RE: Marist Catholic College North Shore (SSD-10473). Response to Submissions and peer review. NSW Government, Department Planning, Industry and Environment (DPIE)

This Heritage Impact Statement (HIS-APPENDIX A, B and C) has been prepared in accordance with the DPE Response to Submissions (RtS) for proposed alterations and additions to the Marist Catholic College North Shore (SSD-10473), dated 20th December 2021.

APPENDIX A: SUMMARY TABLE Marist Catholic College North Shore (SSD-10473). Response to Submissions.

Title
STREETSCAPE ELEVATIONS

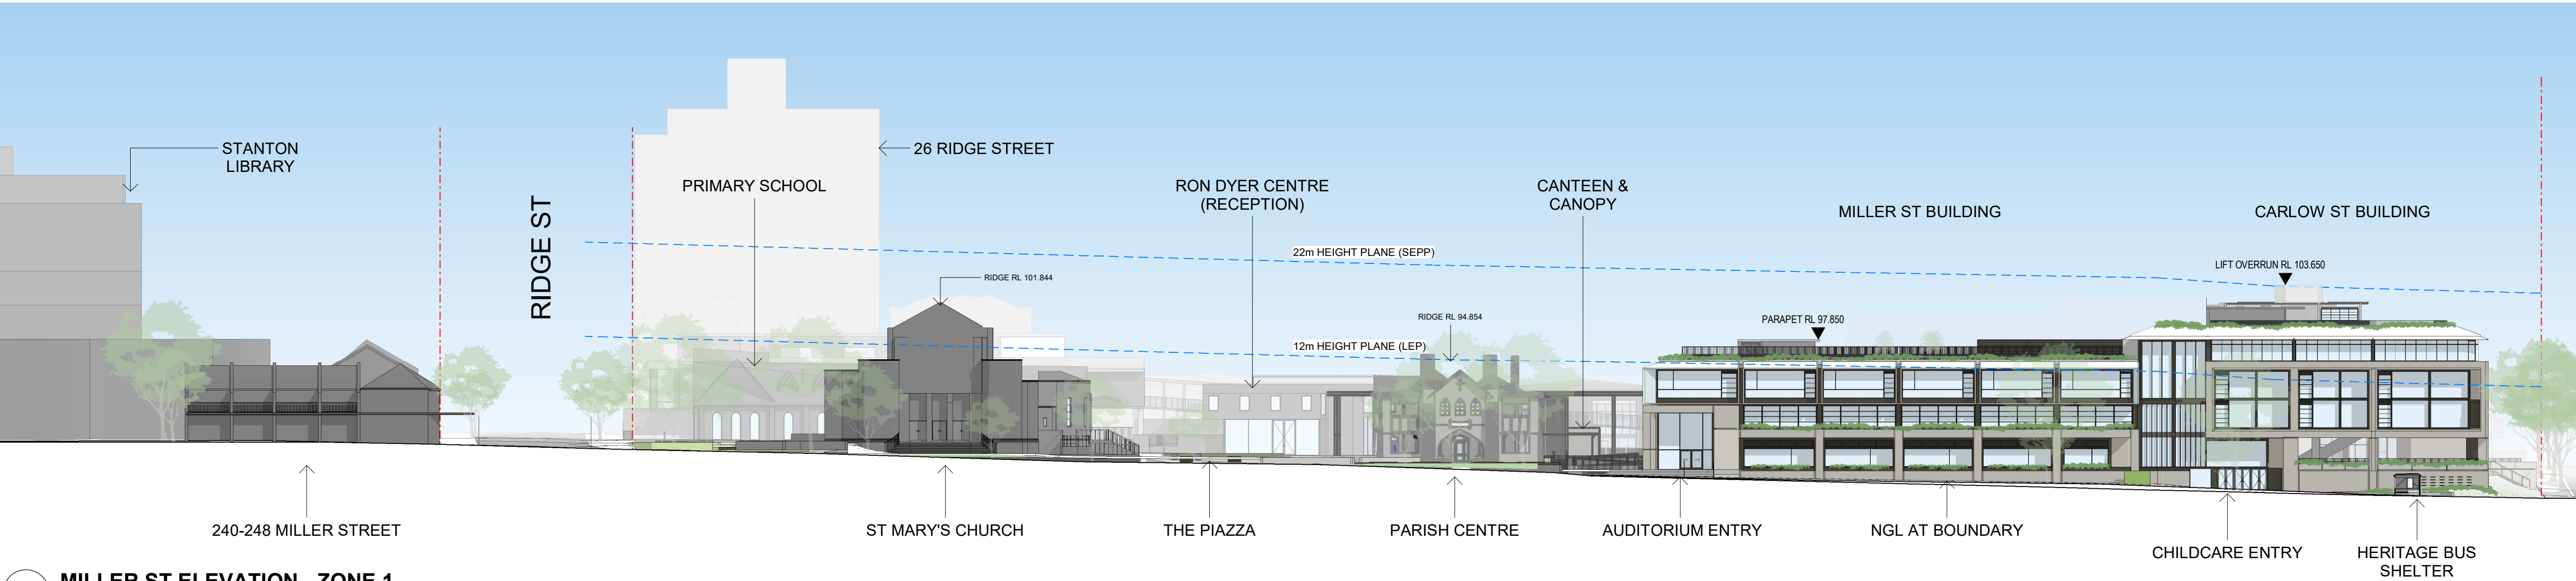
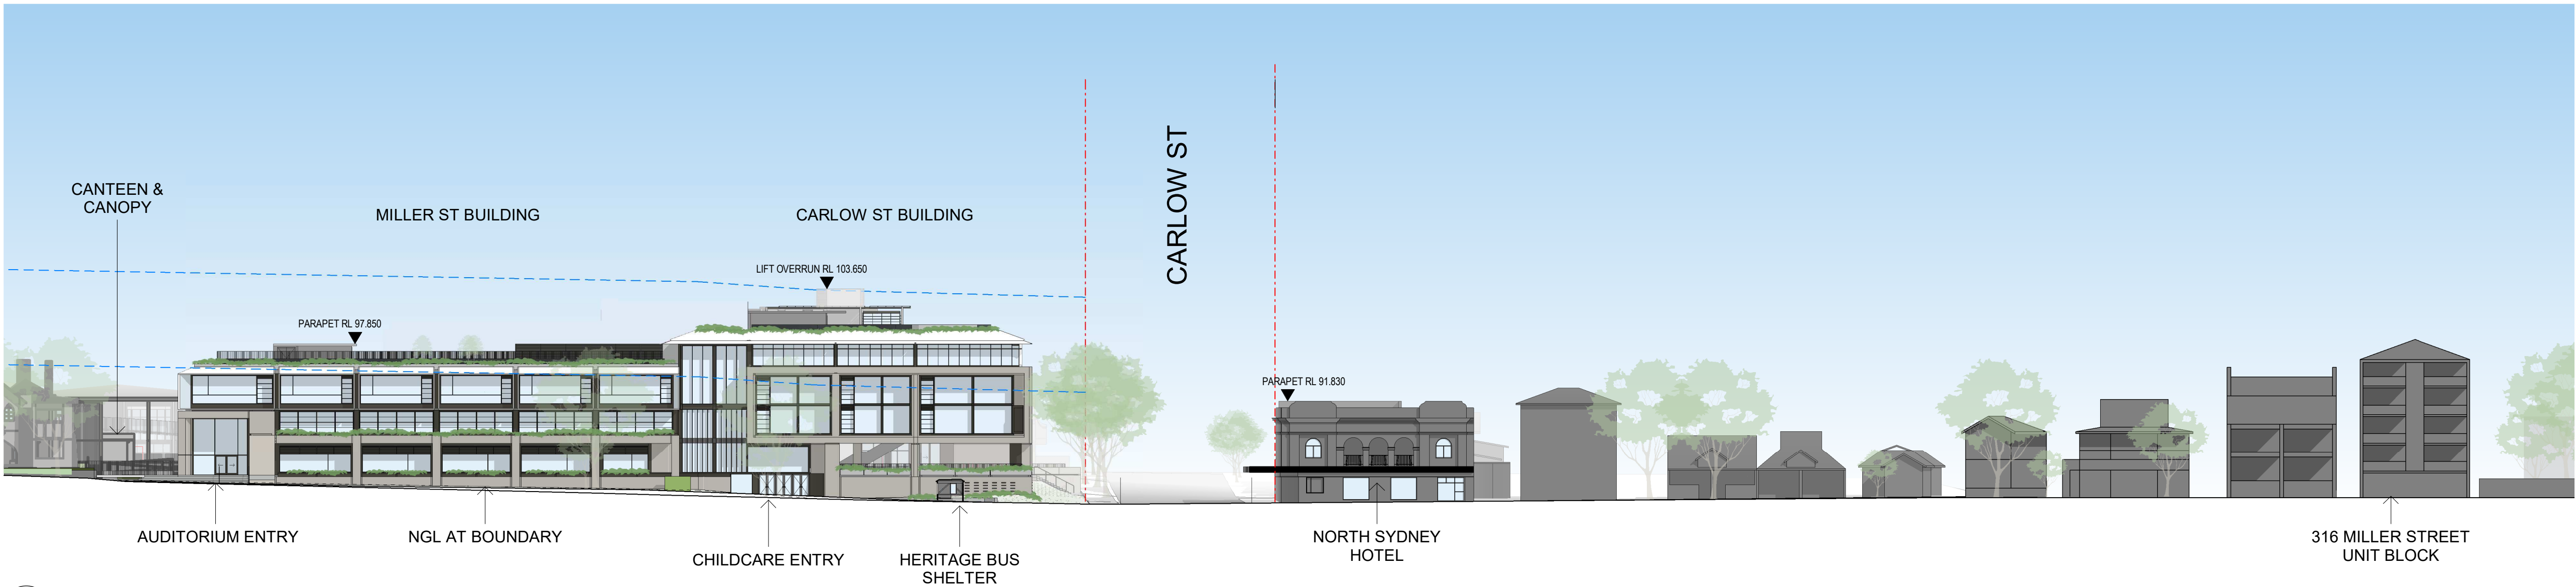
1.0	DPE Comment
	<p><i>the bulk and scale of the building at the corner of Miller and Carlow Street has not been assessed. The Department has raised this concern earlier and considers that the scale of the proposal at this corner should be reduced. The design should be revisited with the goal of being able to provide a proposed corner building of a form, that more sympathetically responds to the heritage aspects of the surrounding context.</i></p>
	<p>The proposed building at the corner of Miller and Carlow Street has been reduced in bulk and scale from the previous scheme, the following amendments have been undertaken:</p> <ul style="list-style-type: none"> • The expressed solid blade forms to the level 3 of the building that originally came out to the lower podium perimeter have been removed, the elevation is now set in to create a reduced visual envelope at this level and provides an appropriate scale relative to the North Sydney Hotel. This is combined with a more streamline glass framing and finely detailed awning that makes the form and scale of the building more recessive. • The proposed scheme is clearly contemporary in style, being finely articulated and considered, utilising a range of quality material and finishes in keeping with and sympathetic to the heritage items in the vicinity and Heritage Conservation Area. • The photo-voltaic panels have been amended to reduce the height of the roof and visual bulk at this level. <p>The proposed building at the Corner of Miller and Carlow Street is located within a diverse urban setting which exhibits various architectural styles, setbacks, building heights, form, scale, landscape and signage including:</p> <ul style="list-style-type: none"> • The four/ five storey Grandstand and entry to the North Shore Oval with open paved and landscaped forecourt. • The contemporary six storey viewing/ media tower and single storey entry booths and fencing to the North Sydney Oval. • The wider setting of the St Leornard's Park with mature tree curtilage to Miller Street. • The five lane carriageway of Miller Street including street signage, traffic lights, large scale overhead cantilevered digital signage and electrical cables. • The contemporary three and four storey rear elevation of the North Sydney Oval Grandstand and colonnade to Miller Street. • The Federation Free Style two and two/three storey North Sydney Hotel. • The proposed, revised building form sits comfortably and sympathetically within this diverse urban context of Heritage items and contemporary urban structures.

No.	DPE Comment	Response
1.0	Revisit design and further assessment on proposed buildings on corner of Miller and Carlow Street	Design has been modified to reduce the impact of the upper levels of the proposal. Assessment of the revised proposal is provided in Appendix A.

Title
ST. MARY'S CHURCH DRAWINGS

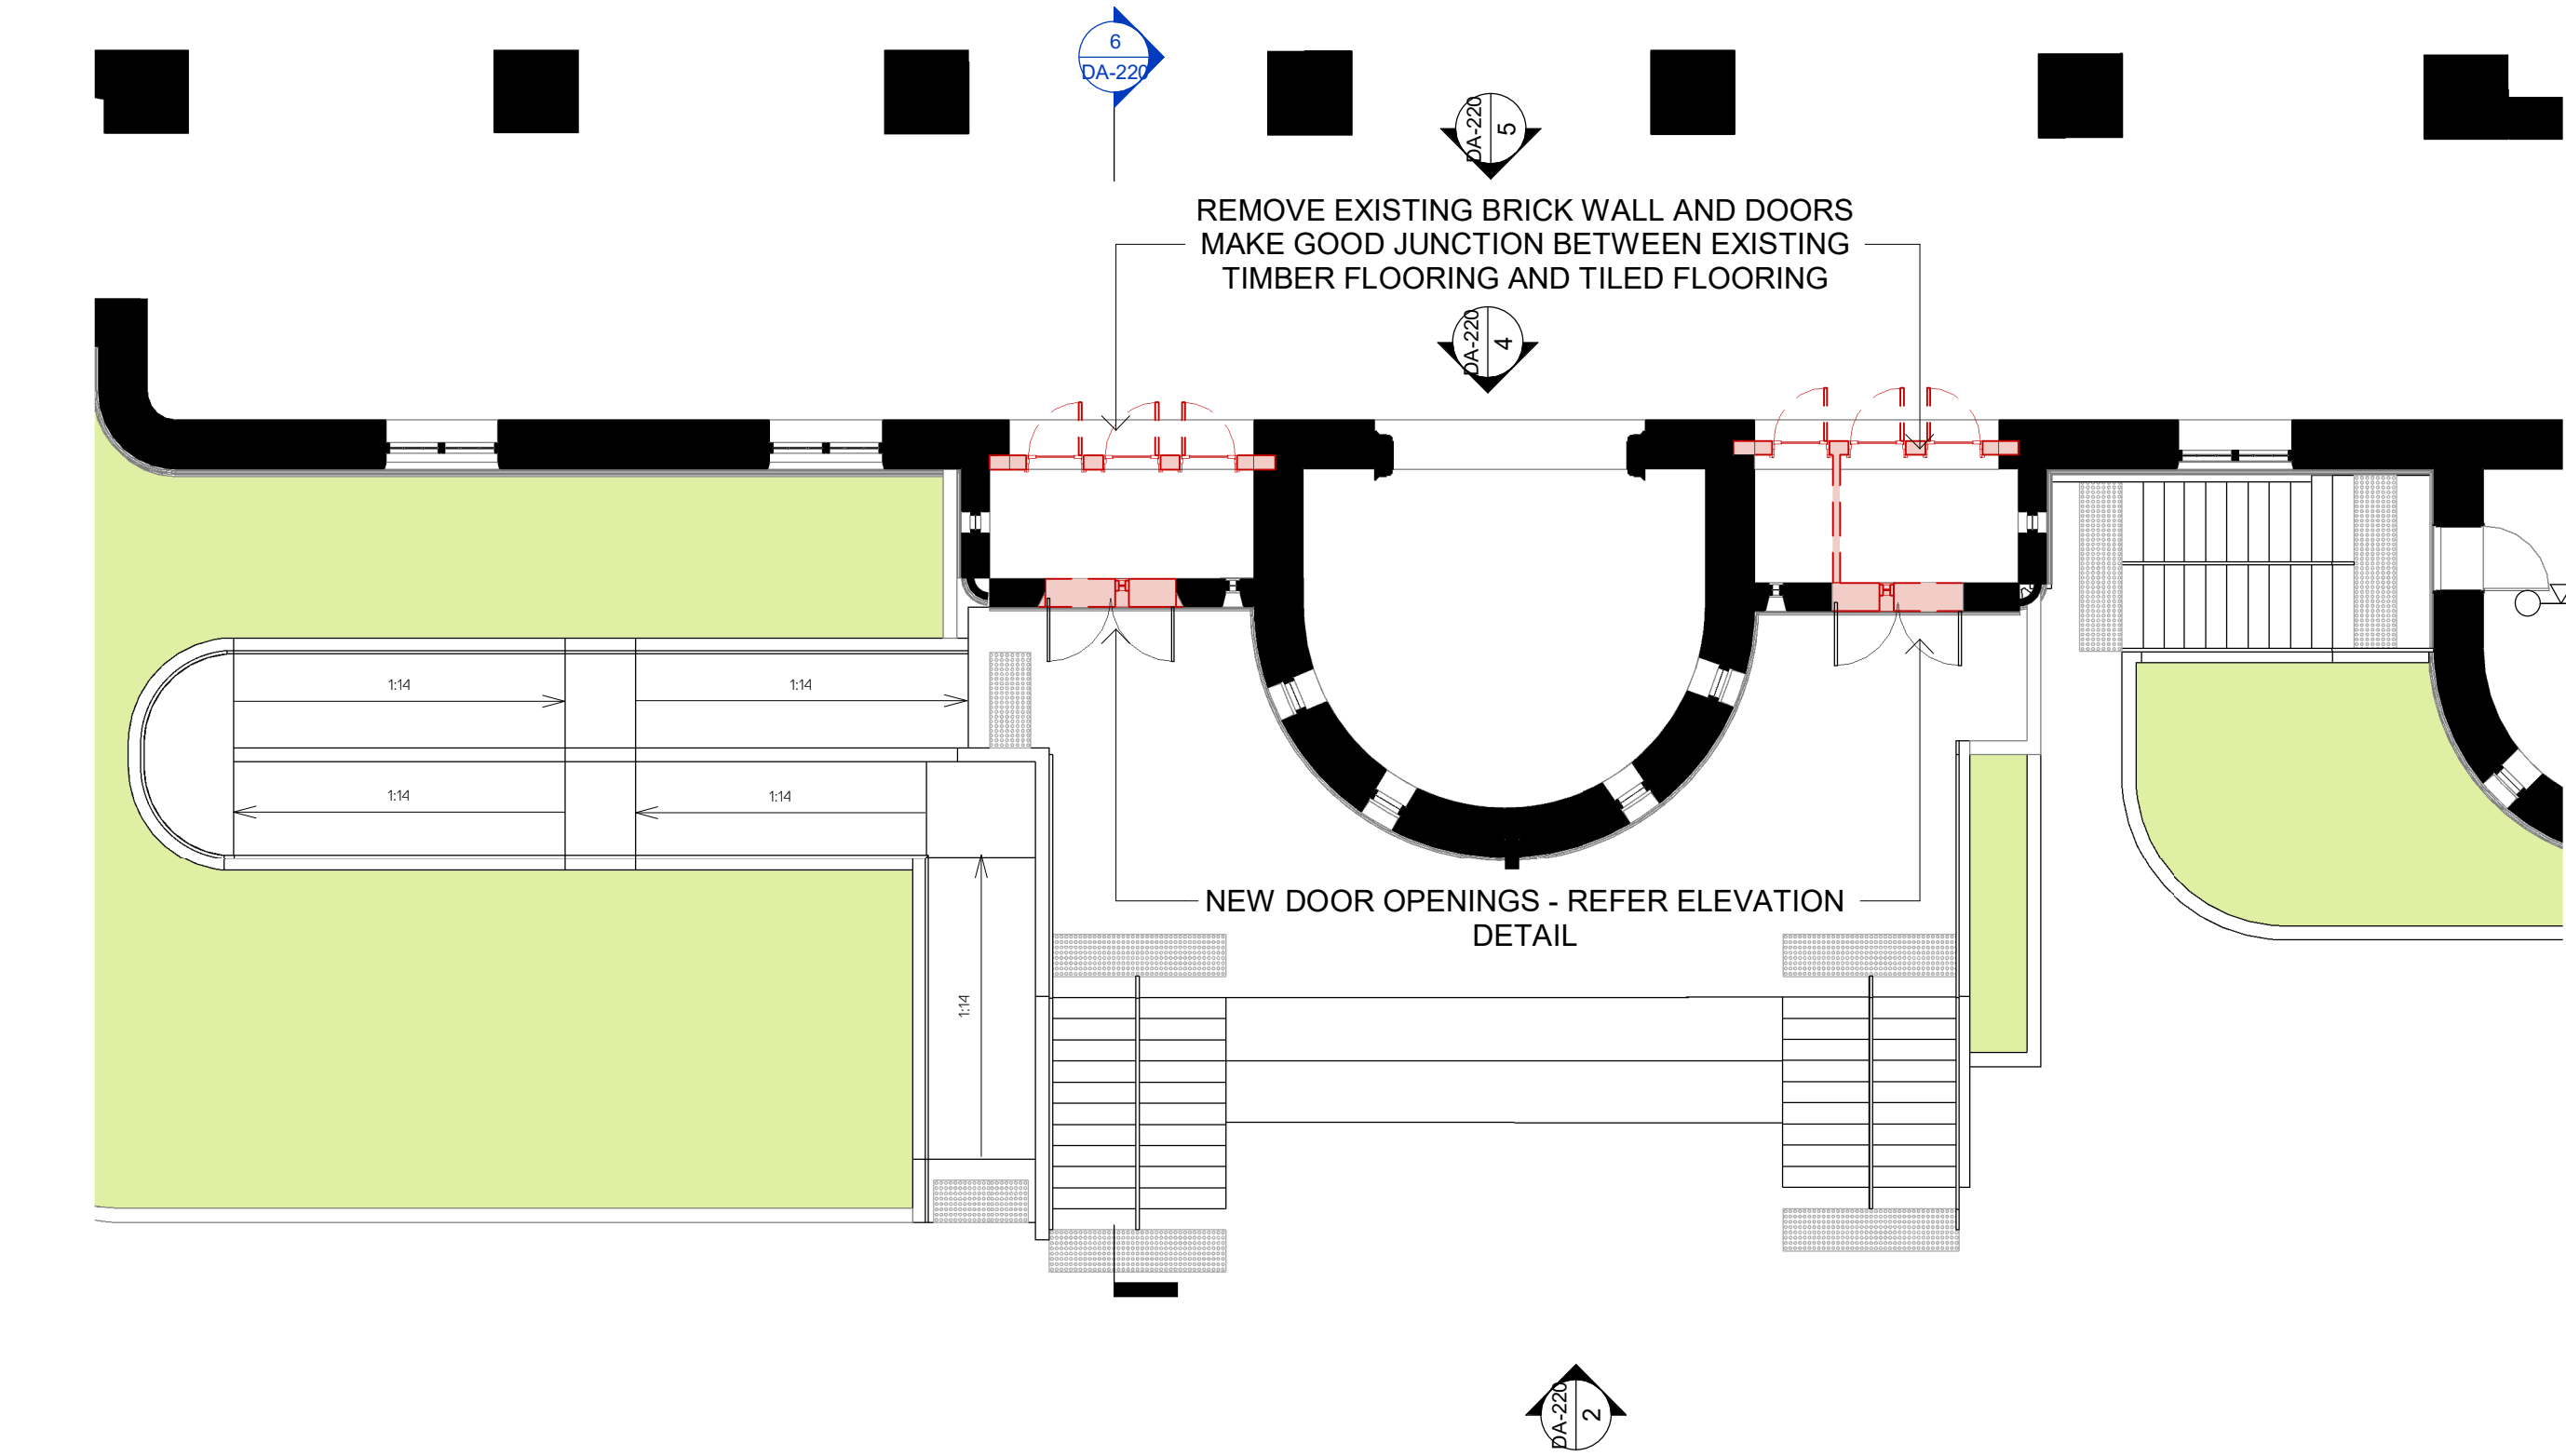
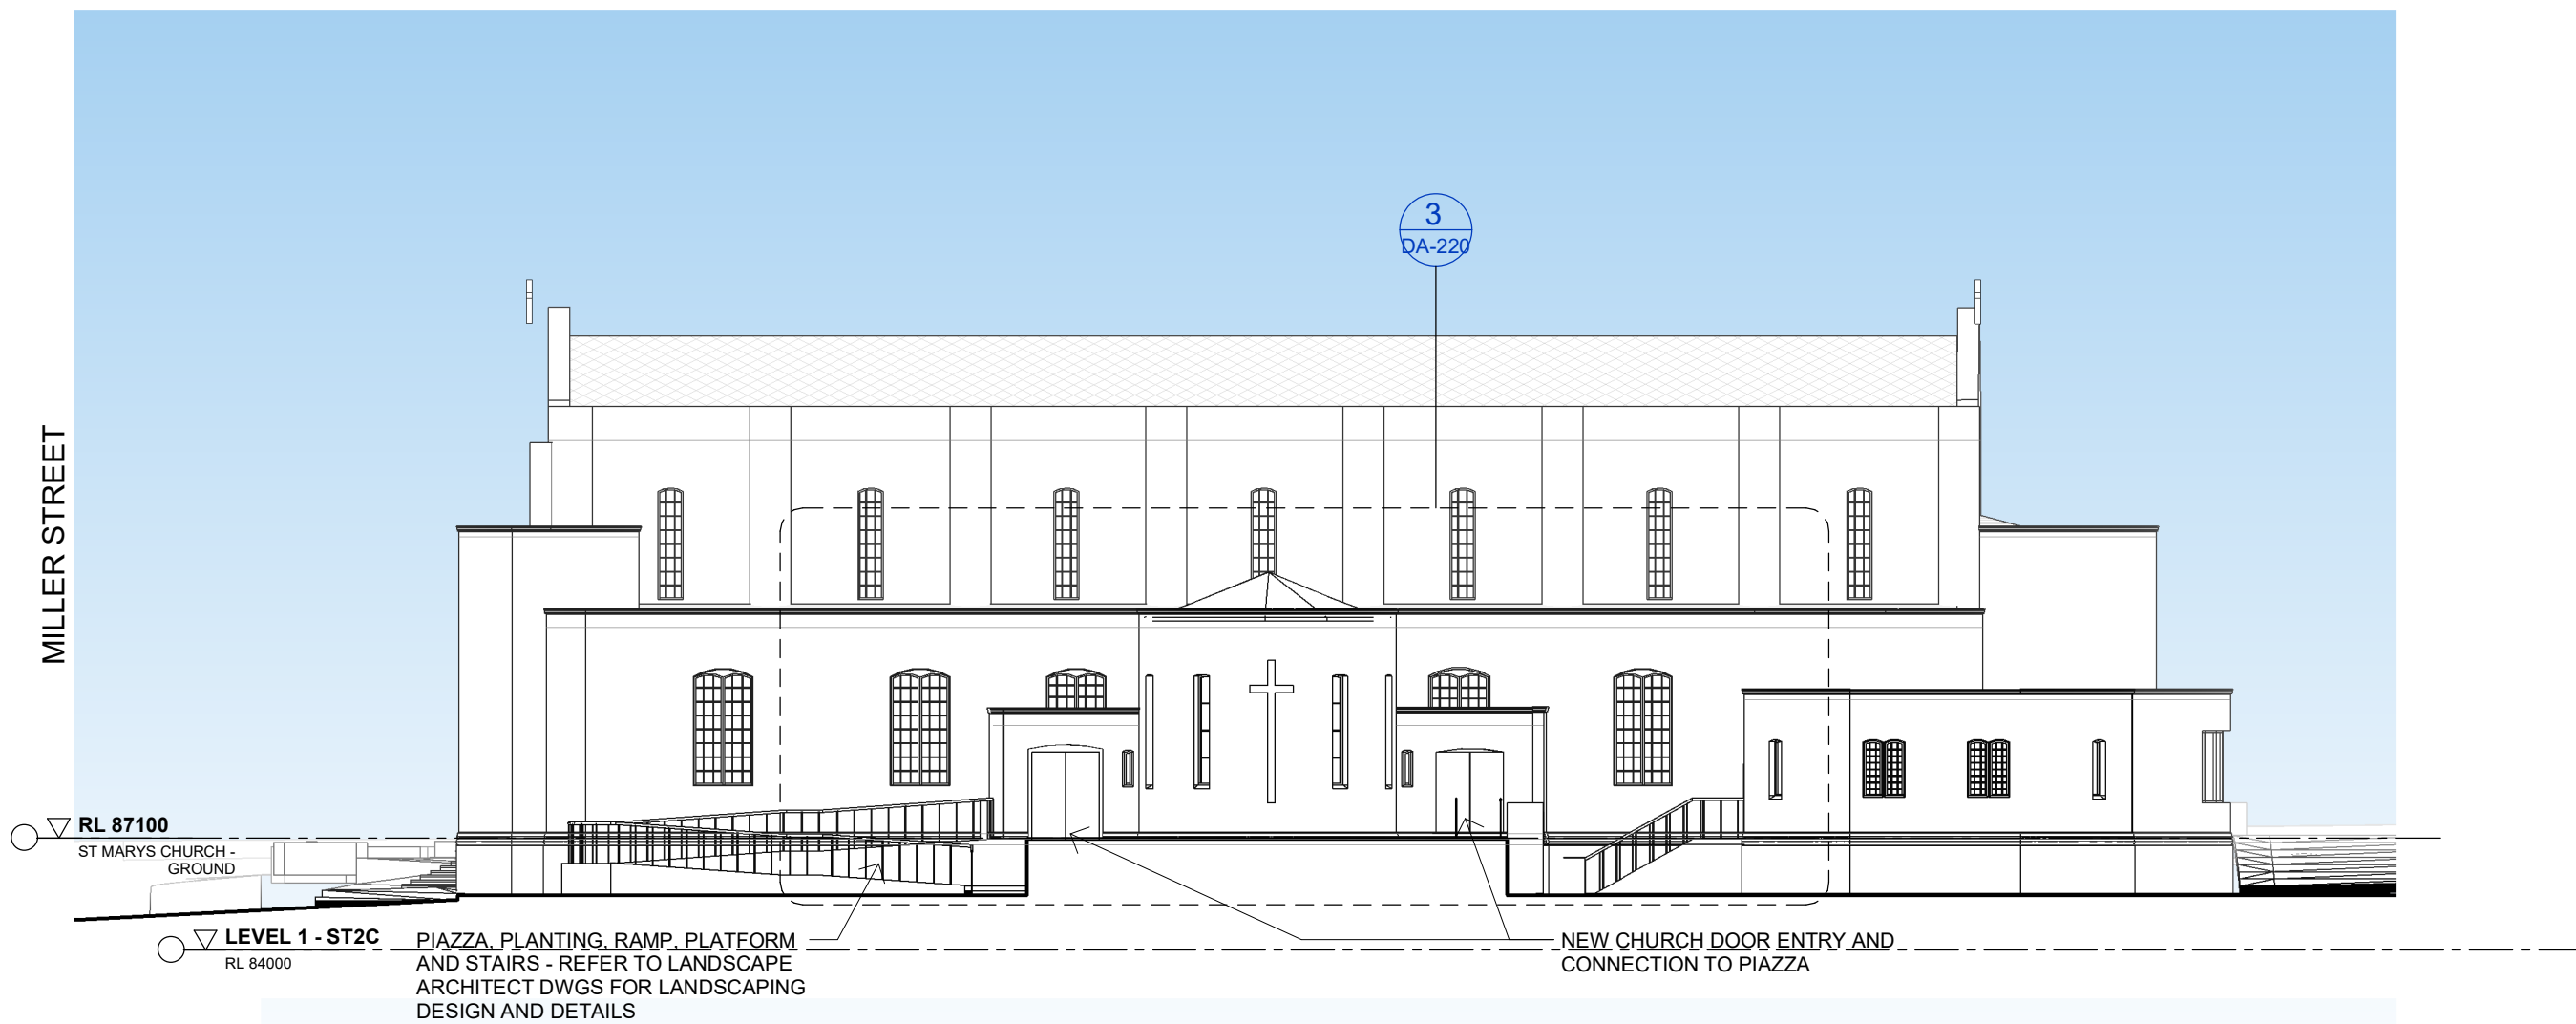
- The proposed works to the Church enable a greater use and compliant wheelchair accessibility to the church and allow it to open out onto the proposed Landscaped piazza.

- The proposed access ramp and handrail to the proposed northern terrace will provide compliant access to the church and will not impact on any heritage fabric of the church. The access ramp and handrail is at a low height within a landscape setting and will remain visually recessive to the bulk, height, form and scale of the Church building.

- The proposed northern terrace will sit below and not disturb the established, low level sandstone band of the church. The proposed sand coloured large format granite pavers will reflect and interpret the sandstone use at the main entry to the Church.

- The original drawings for the Church indicate that the existing southern entry sandstone low walls (in the southern Garden) to the access ramp may not be original. The ramp will be carefully photographed and relocated 280mm to the south of its current location to provide compliant accessibility to the church.
